Department of Industry

OUT19/2623

Huntlee Stage 1 Modification 10 (10_0137) Environmental Assessment

Figure 4 | Proposed modifications under Mod 10

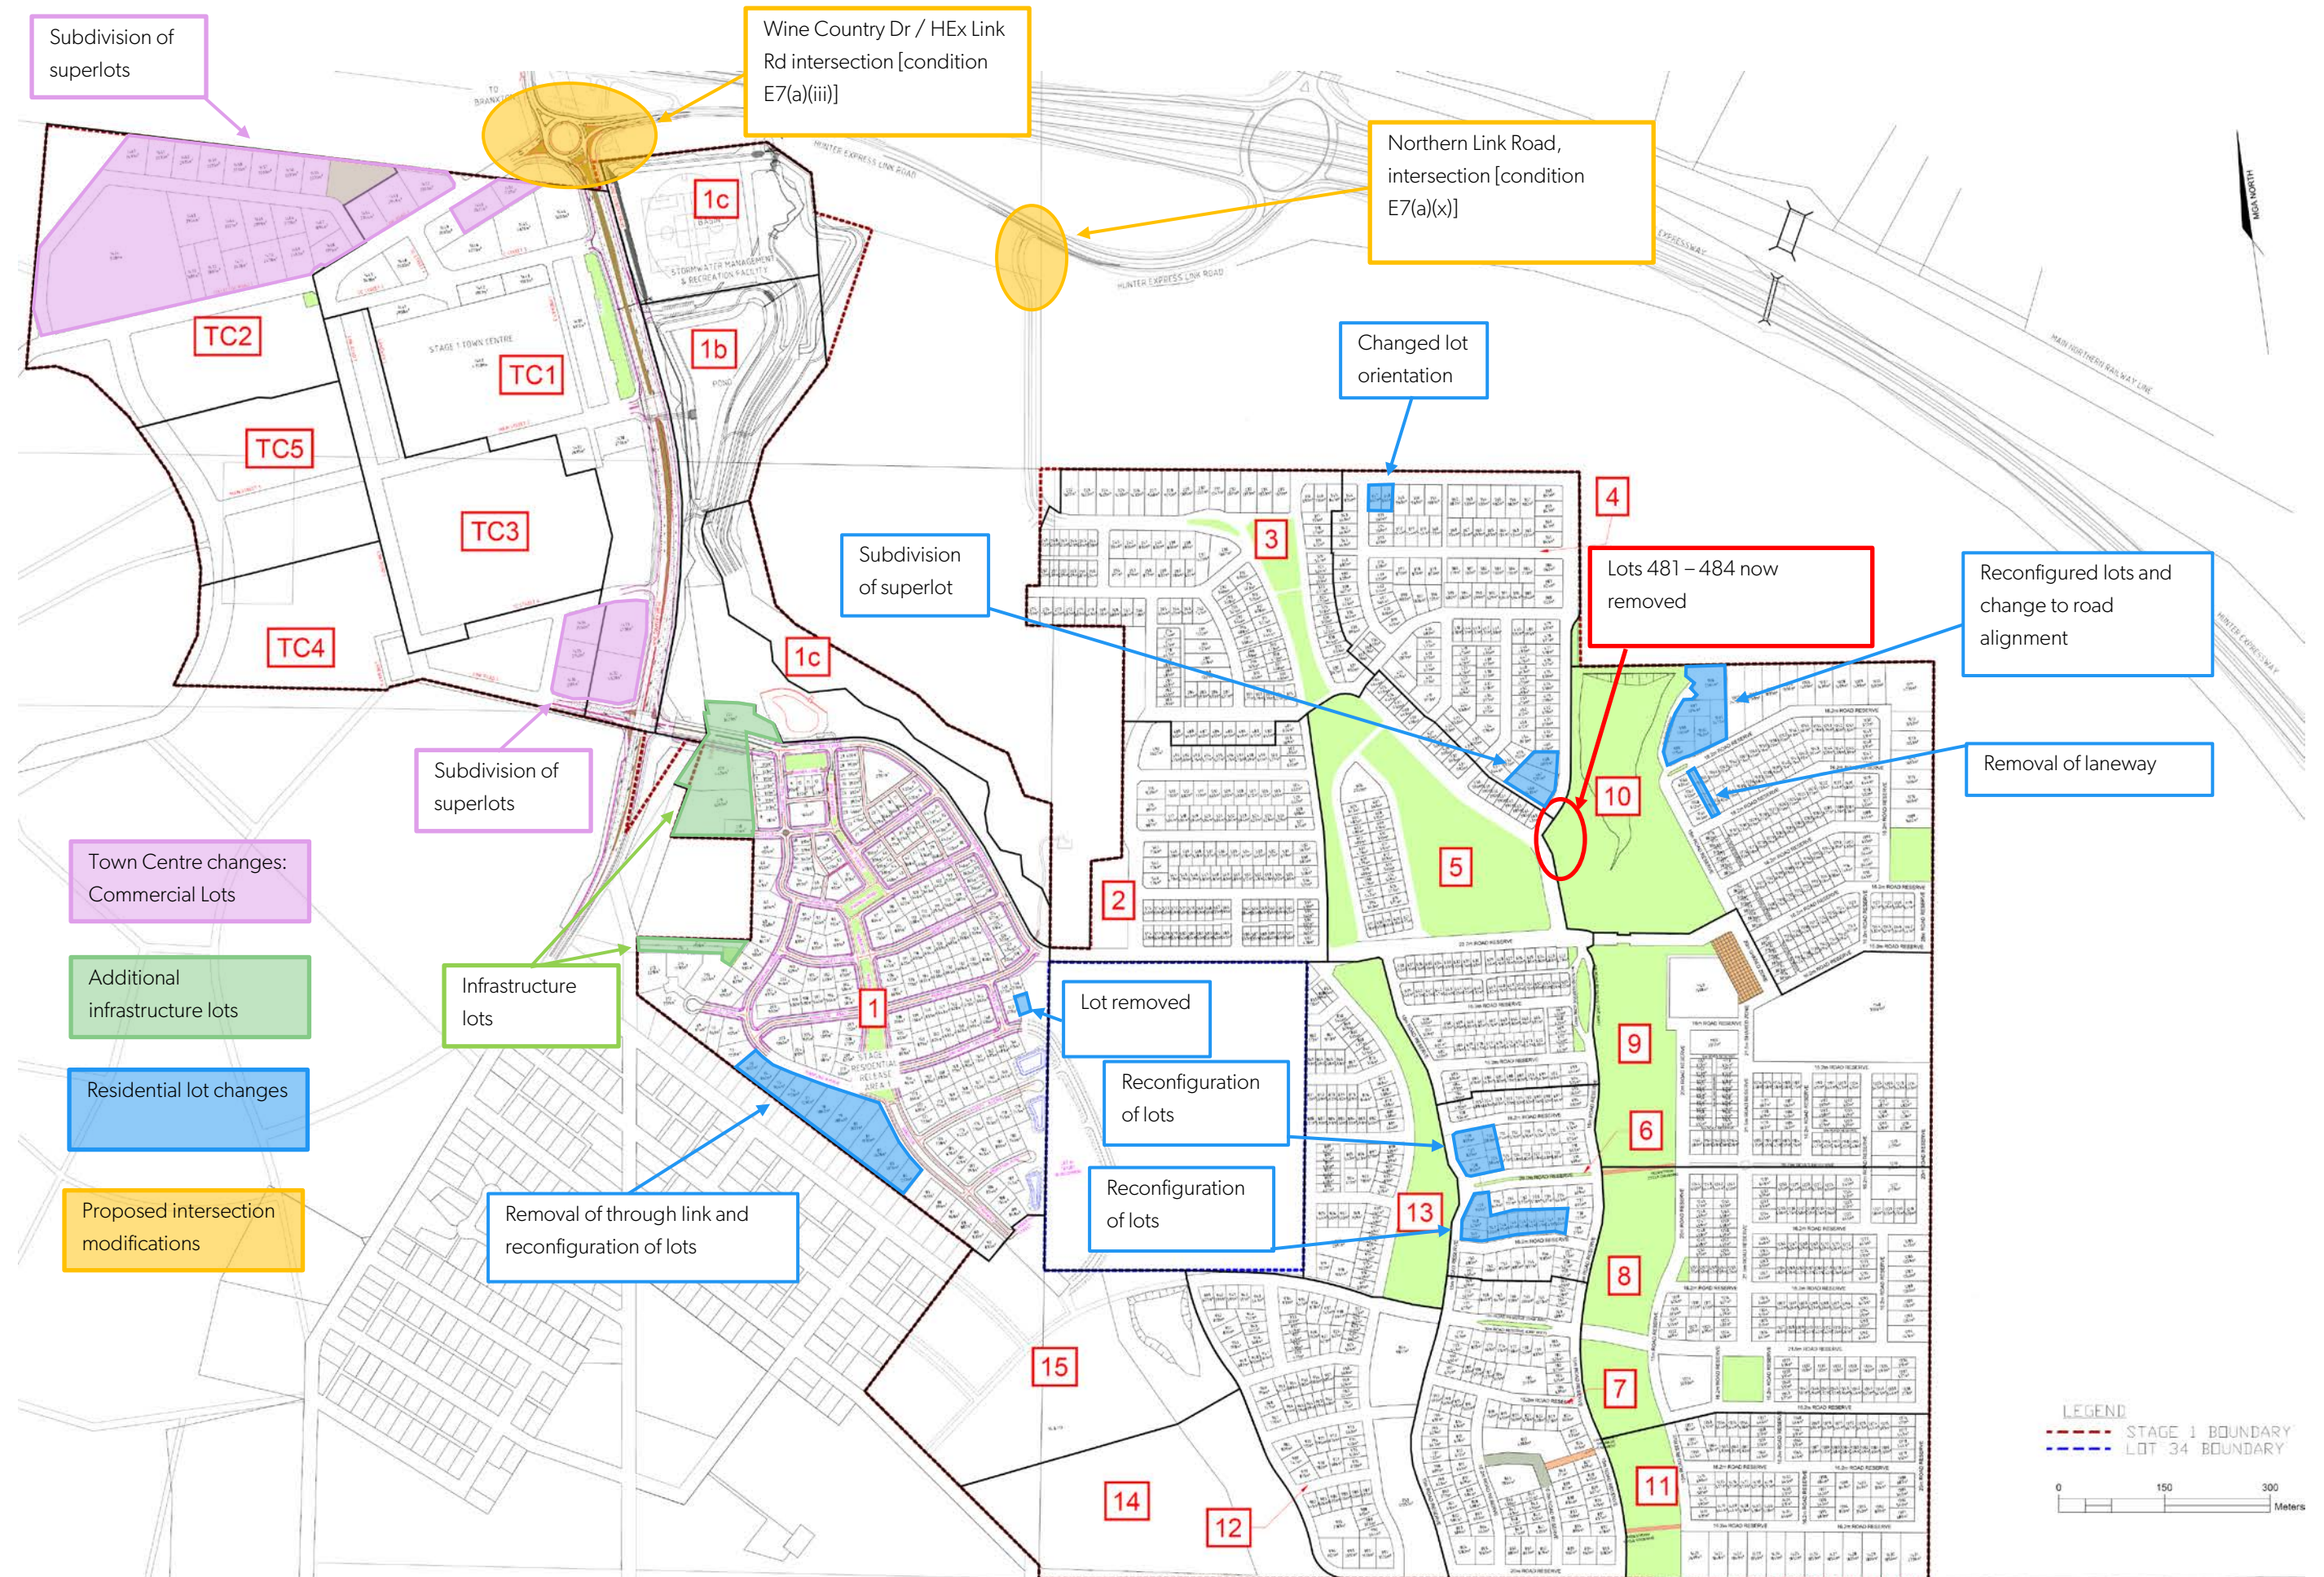
The environmental assessment has identified that an additional four lots are proposed in substage 5 on the boundary of a 2nd order stream. The proponent should provide additional information including drawings identifying riparian corridor widths and asset protection zones outside of the Vegetation Riparian Zones. Guidelines for working on waterfront lands can be accessed at <https://www.industry.nsw.gov.au/water/licensing-trade/approvals/controlled-activities> and should be used to identify all riparian corridors, stream orders and associated infrastructure on waterfront land.
